WEST SUSSEX COUNTY COUNCIL CONSULTATION

TO:	Arun District Council FAO: Zac Denton
FROM:	WSCC - Highways Authority
DATE:	13 August 2020
LOCATION:	12 Wick Farm Road, Littlehampton, BN17 7HR
SUBJECT:	LU/195/20/PL Erection of 1 No. single storey flatlet dwelling.
DATE OF SITE VISIT:	N/A
RECOMMENDATION:	Advice
S106 CONTRIBUTION TOTAL:	N/A

Proposed Flatlet extension on East side of 12 Wick Farm Road, Littlehampton: AS PROPOSED

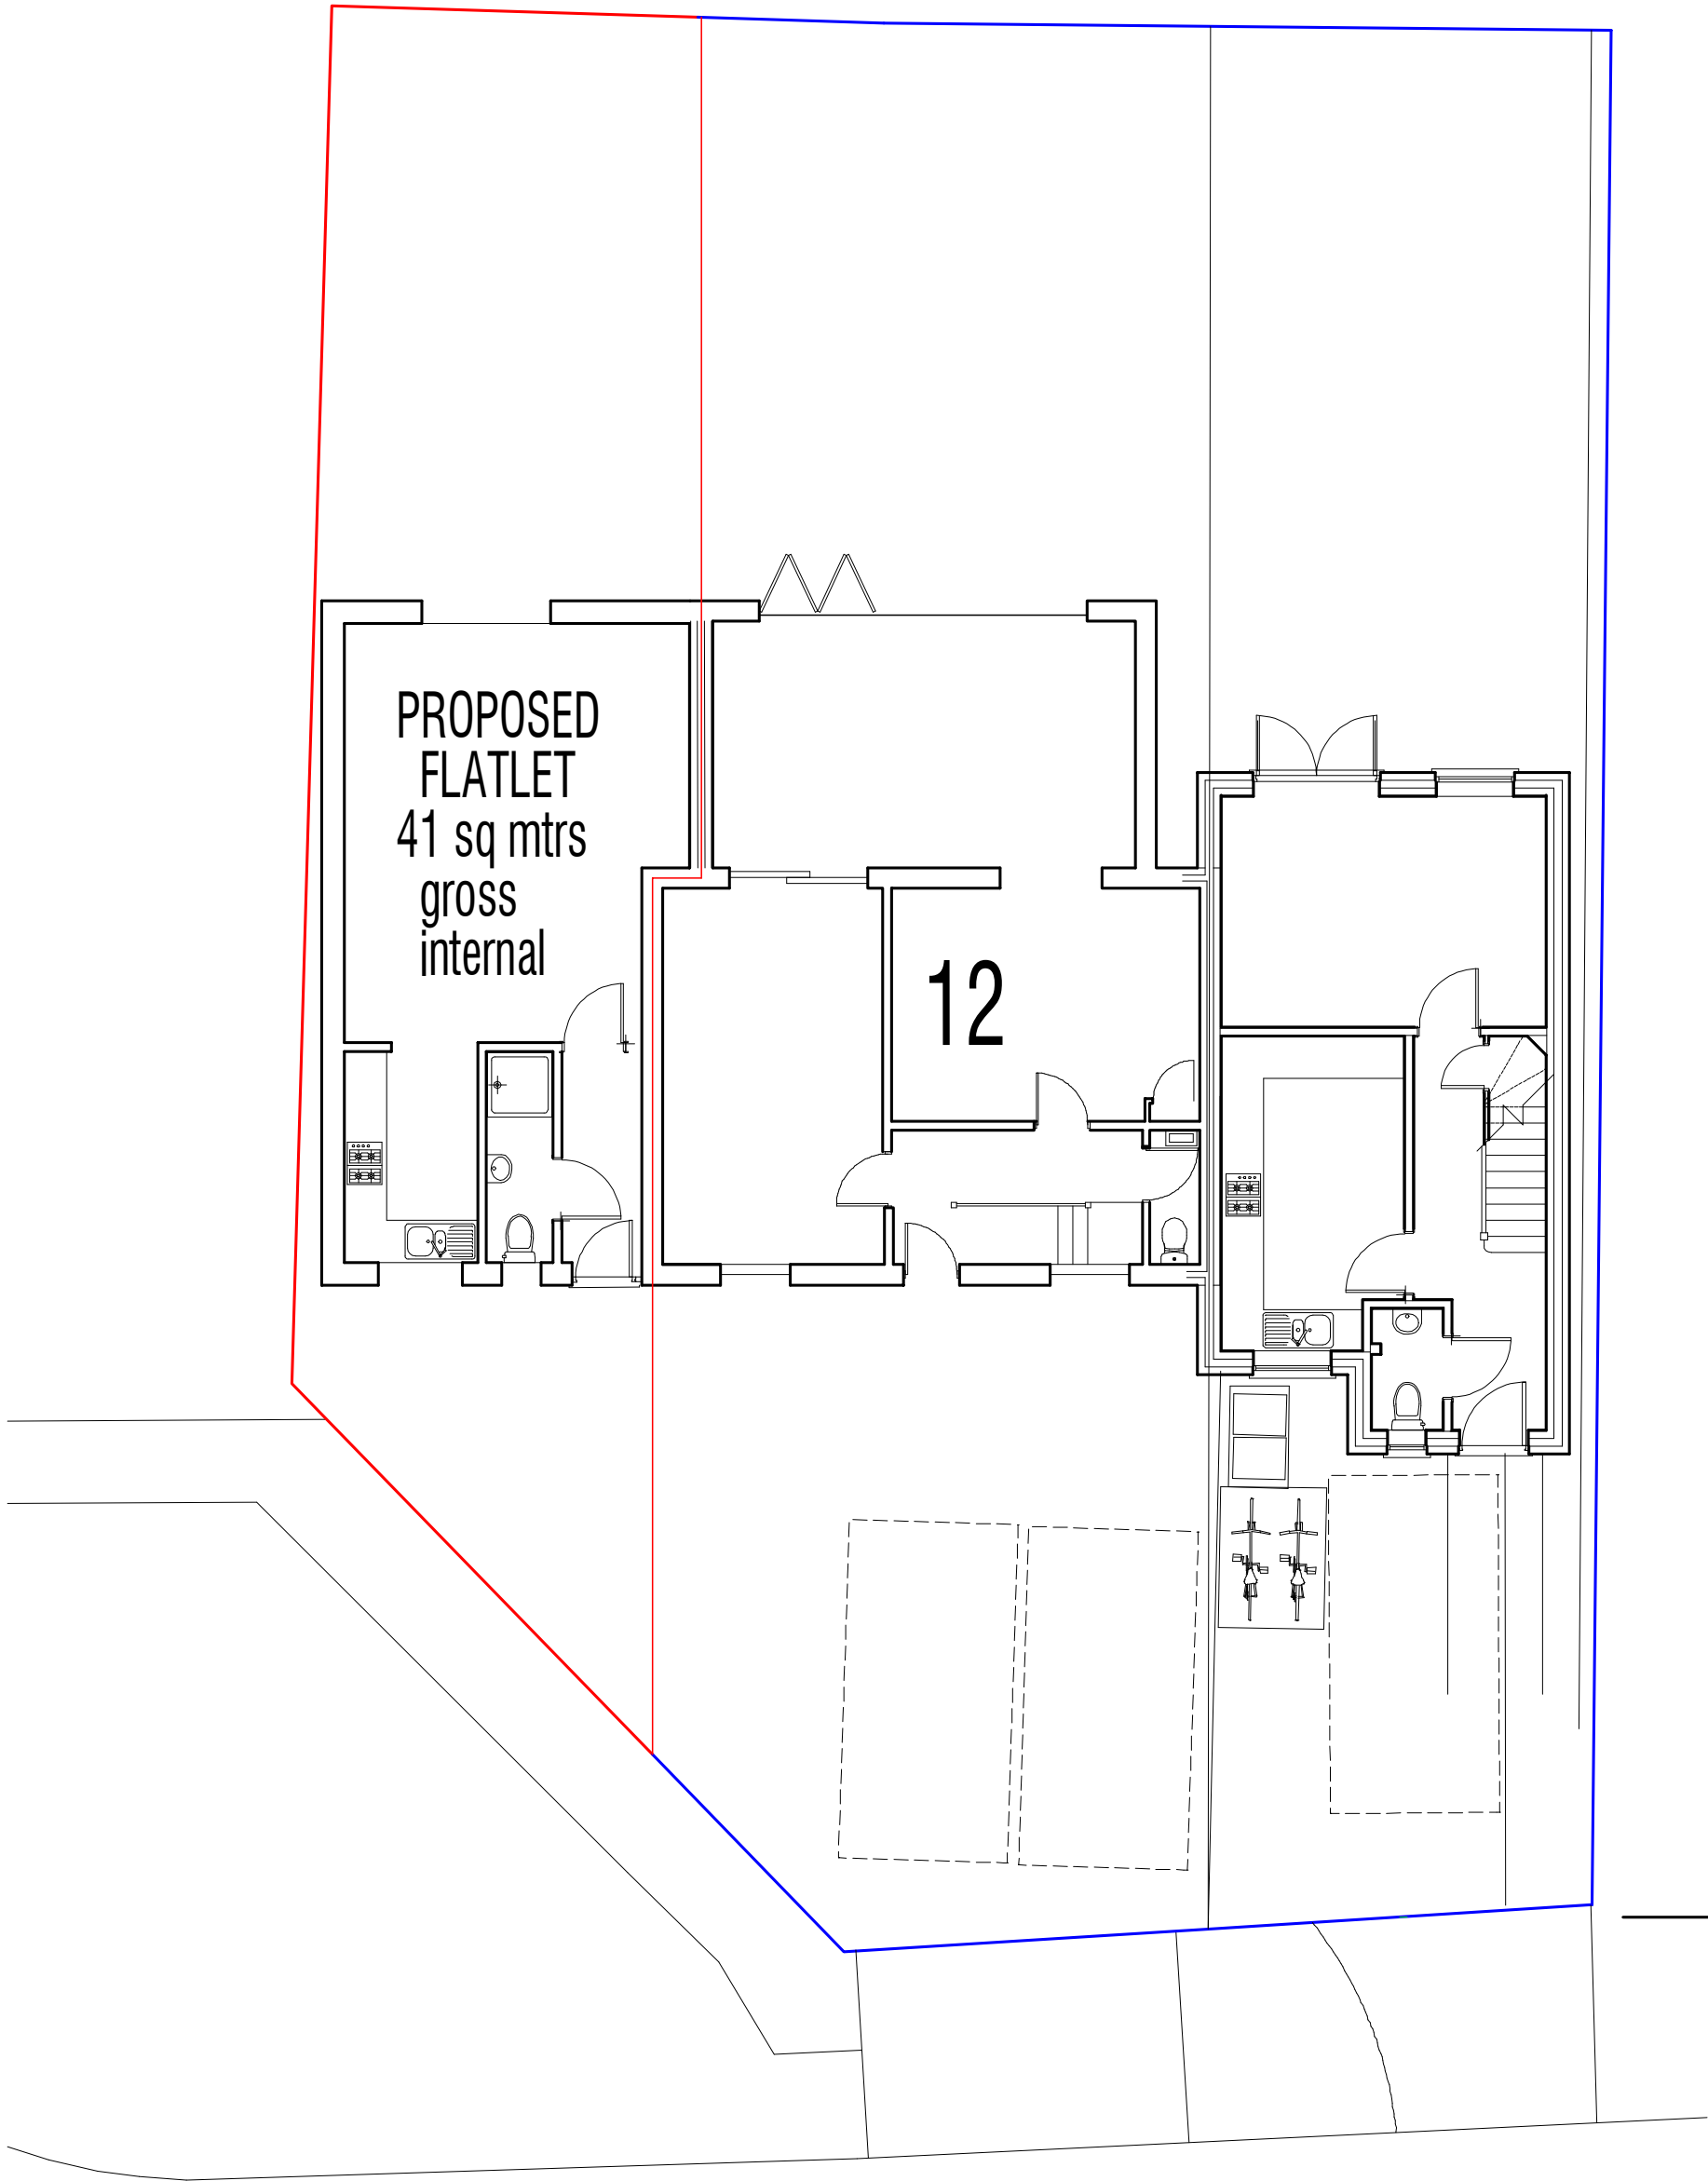
The applicant proposes a nil car parking provision. Under Arun Parking Standards, the applicant should provide two car parking spaces for a dwelling of this size in this location. As such, vehicles would have to be accommodated on-street. The nearby road network benefits from unrestricted on-street parking. The LHA does not anticipate that the proposed nil car parking provision would result in any highway safety or capacity issues. The LPA may wish to consider the potential impacts on on-street parking from an amenity point of view. Weight is given that the site is situated in a sustainable location with walking/cycle distance from local amenities, services and public transport links.

The applicant has not demonstrated cycle parking provision. Cycling is a viable option in the area and therefore, the LHA would like to see the implementation of secure and covered cycle parking provision for this application. A suitably worded condition is included below.

No part of the development shall be first occupied until covered and secure cycle parking spaces have been provided in accordance with plans and details to be submitted to and approved by the Local Planning Authority.
